CITY OF ALBUQUERQUE  
PLANNING DEPARTMENT  
DEVELOPMENT REVIEW BOARD

### **Project# 1009843**

13DRB-70792 VACATION OF PUBLIC ROADWAY EASEMENT  
14DRB-70001 MINOR - PRELIMINARY/ FINAL PLAT APPROVAL  
14DRB-70003 SUBDN DESIGN VARIANCE FROM MIN DPM STDS

**CITY OF ALBUQUERQUE  
PLANNING DEPARTMENT  
January 22, 2014  
DRB Comments**

PLAT OF  
**ALEESA COURT SUBDIVISION**  
 SITUATE WITHIN  
**PROJECTED SECTION 18**  
**T.11N., R.4E., N.M.P.M.**  
**ELENA GALLEGOS LAND GRANT**  
**CITY OF ALBUQUERQUE**  
**BERNALILLO COUNTY, NEW MEXICO**  
 JANUARY 2014

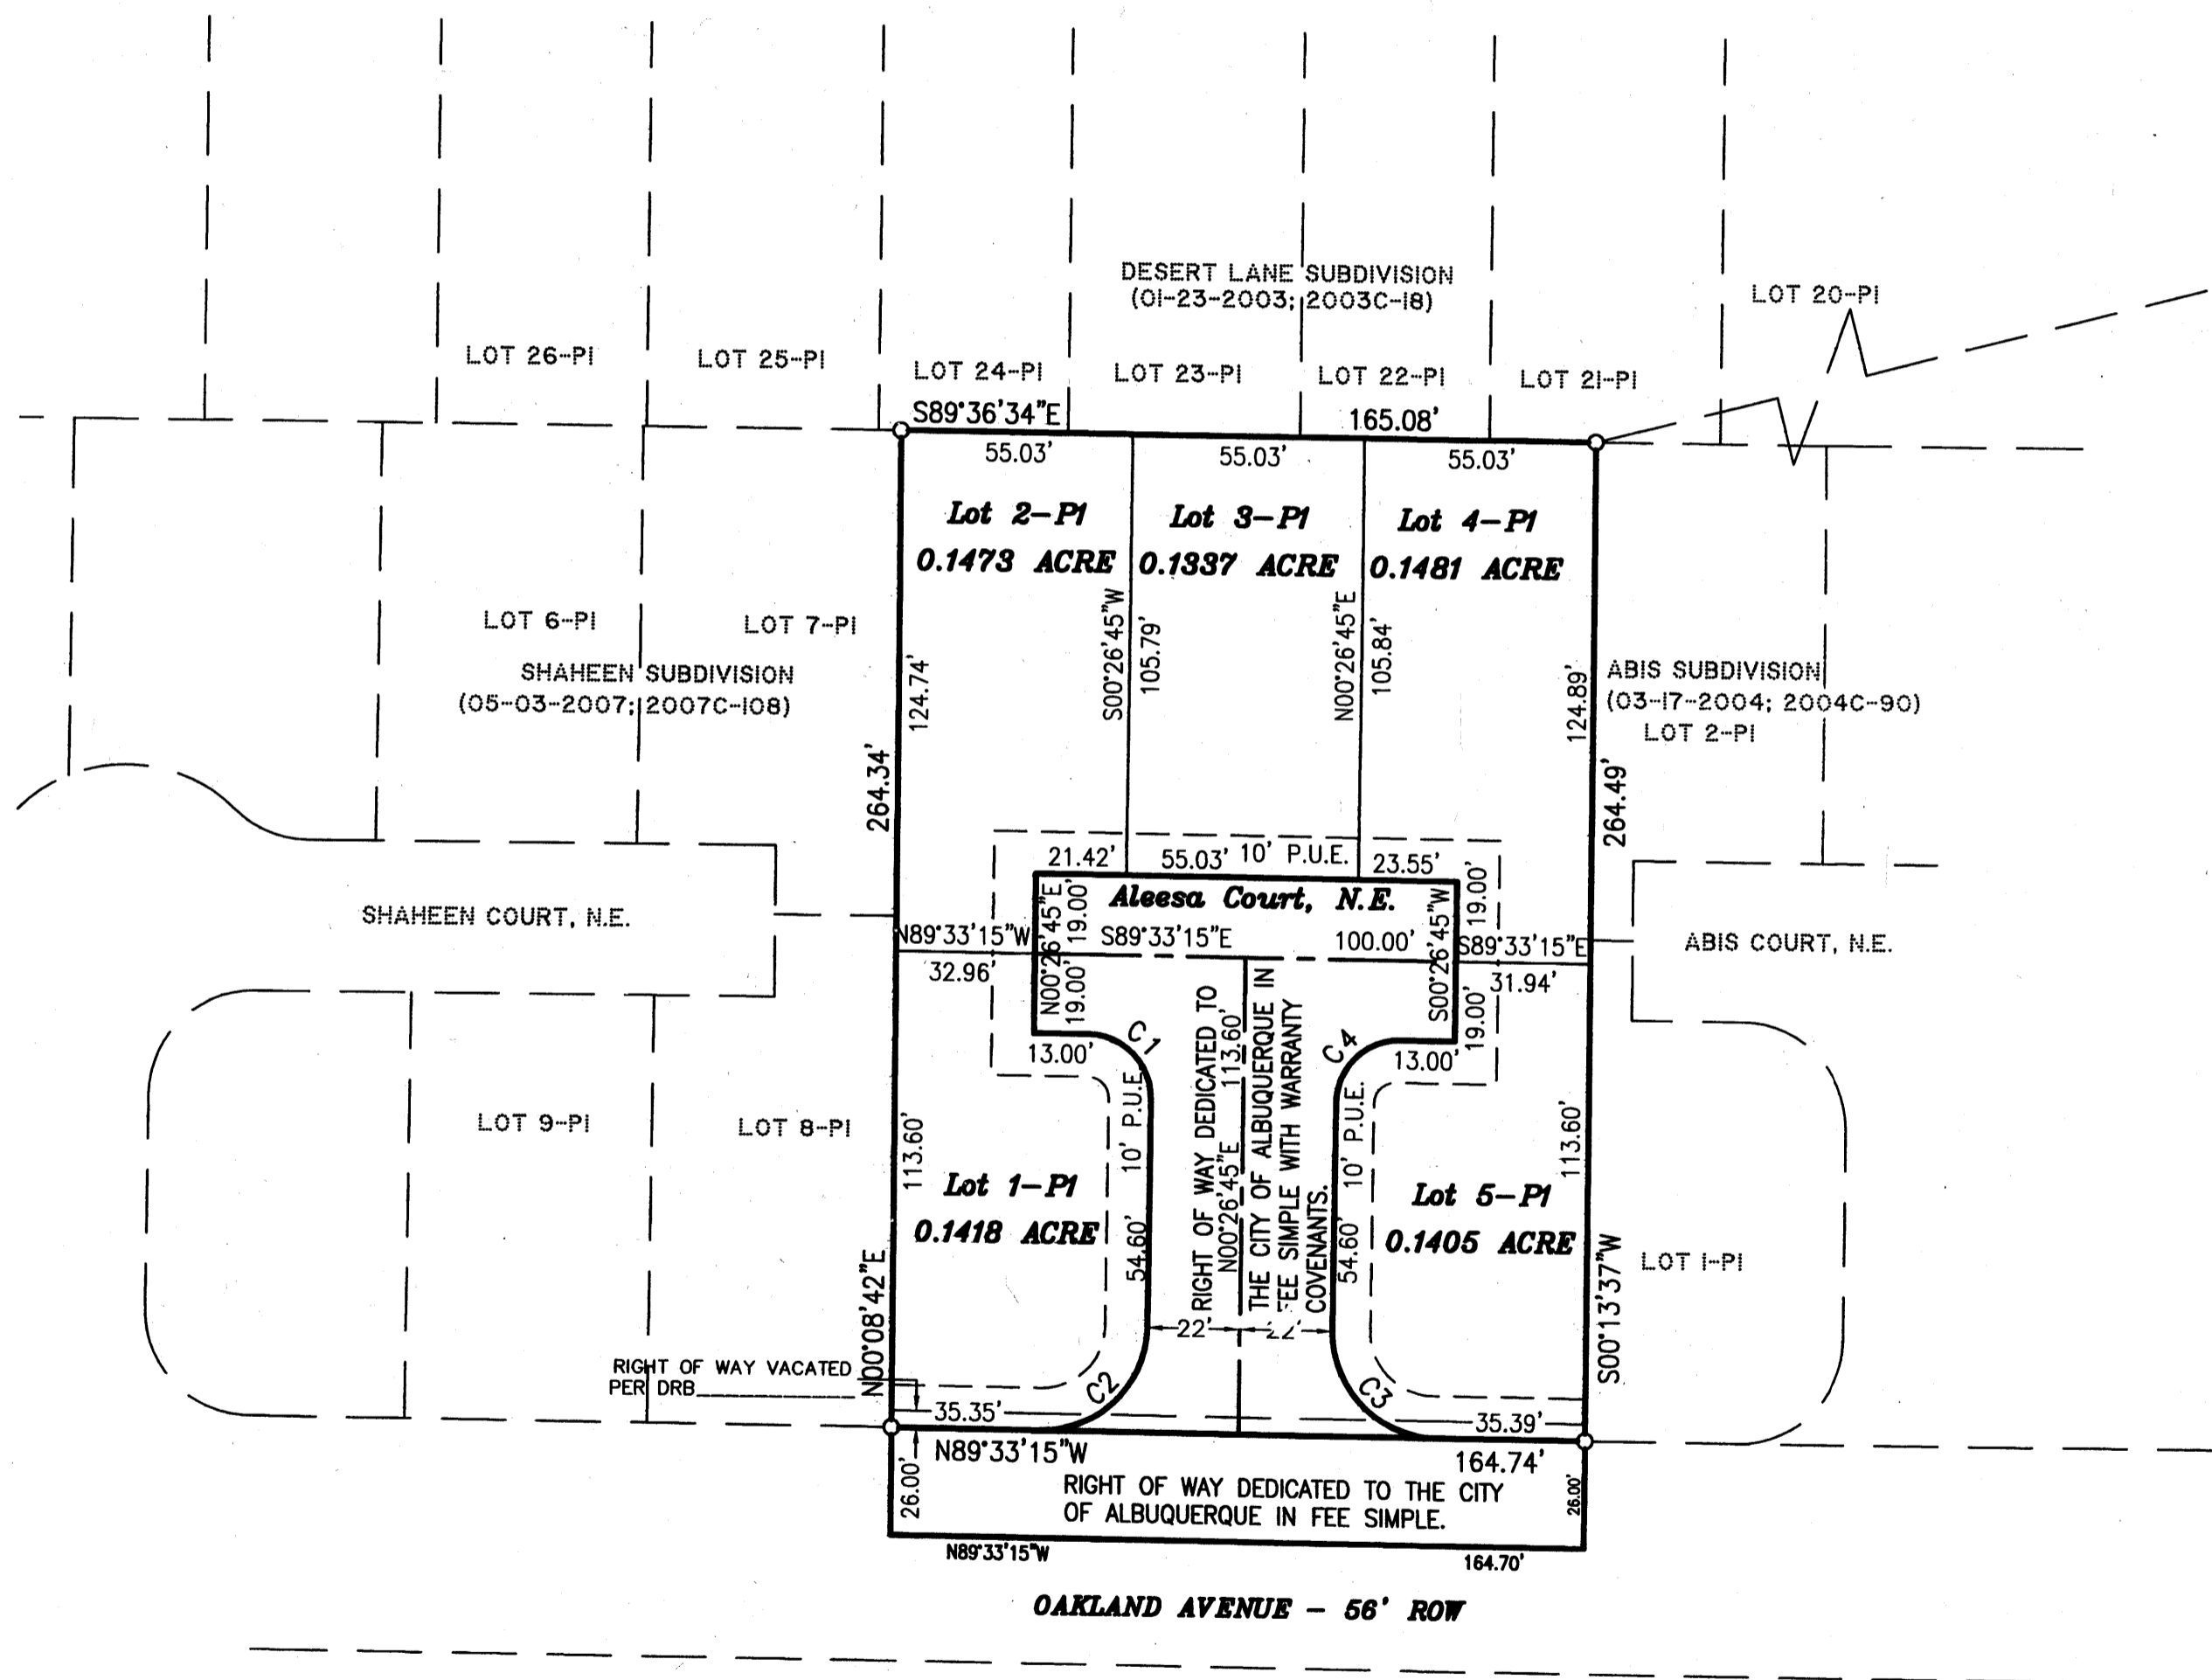
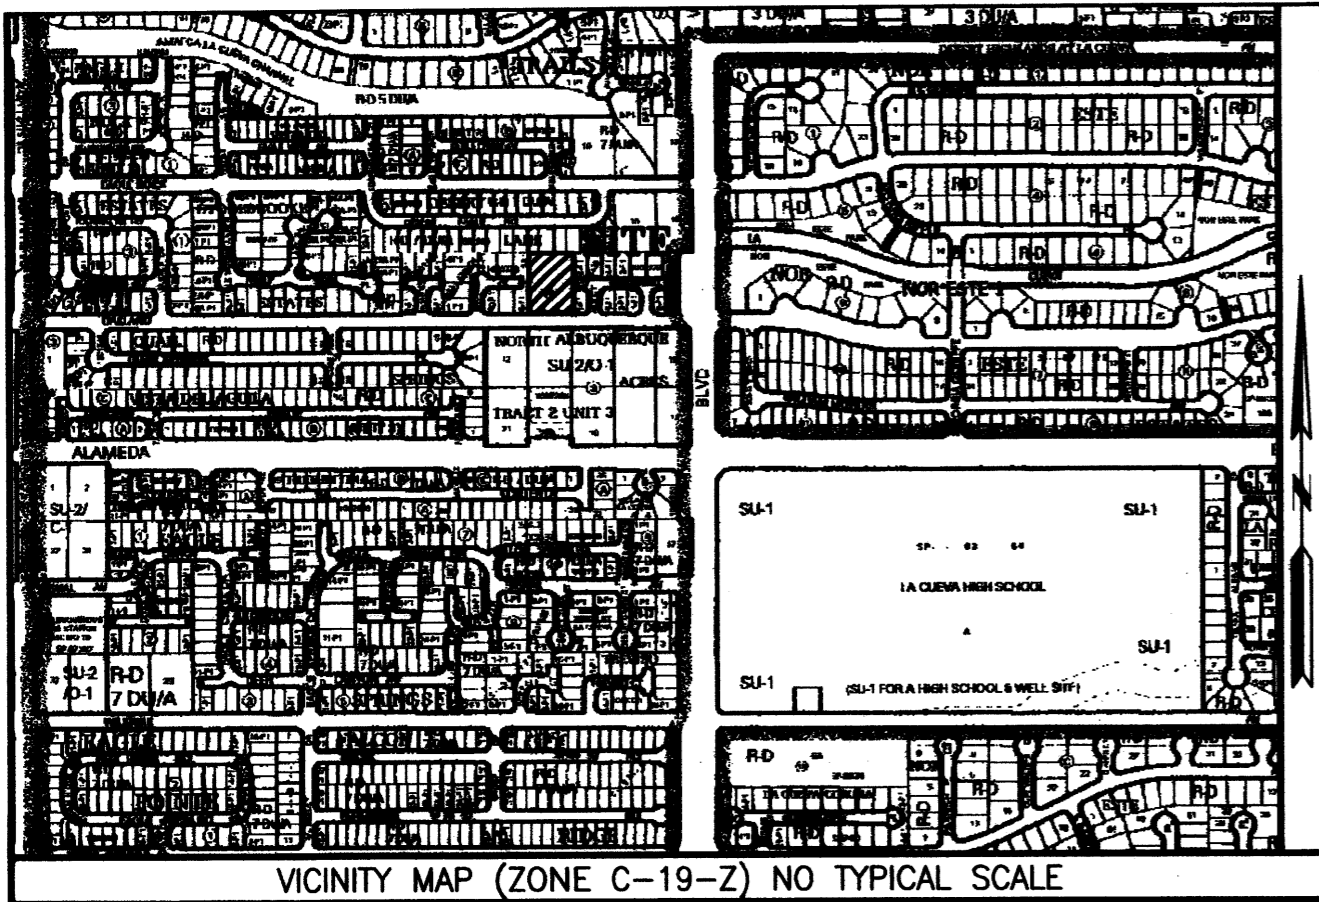
A recorded Subdivision Improvements Agreement/ SIA or completion and acceptance of infrastructure is required for Final Plat. Please remove Zoning Note (No. 5) from Final Plat.

Please note that maximum wall height in a residential zone is 8 feet; clear sight triangles need to be demonstrated.

A recorded Subdivision Improvements Agreement/ SIA or completion and acceptance of infrastructure is required for Final Plat, as well as owners' and City Surveyor's approval and signature. Please remove Zoning Note (No. 5) from Final Plat.

Please note that maximum wall height in a residential zone is 8 feet and minimum pilaster projection is 2 inches; clear sight triangles need to be demonstrated.

1. The vacated property shall be shown on a replat approved by the Development Review Board and the approved replat shall be filed for record with the Bernalillo County Clerk's Office within one year.
2. Zoning Note (5) shall be removed for the Final Plat.
3. The wall exhibit shall note a maximum height of 8 feet.
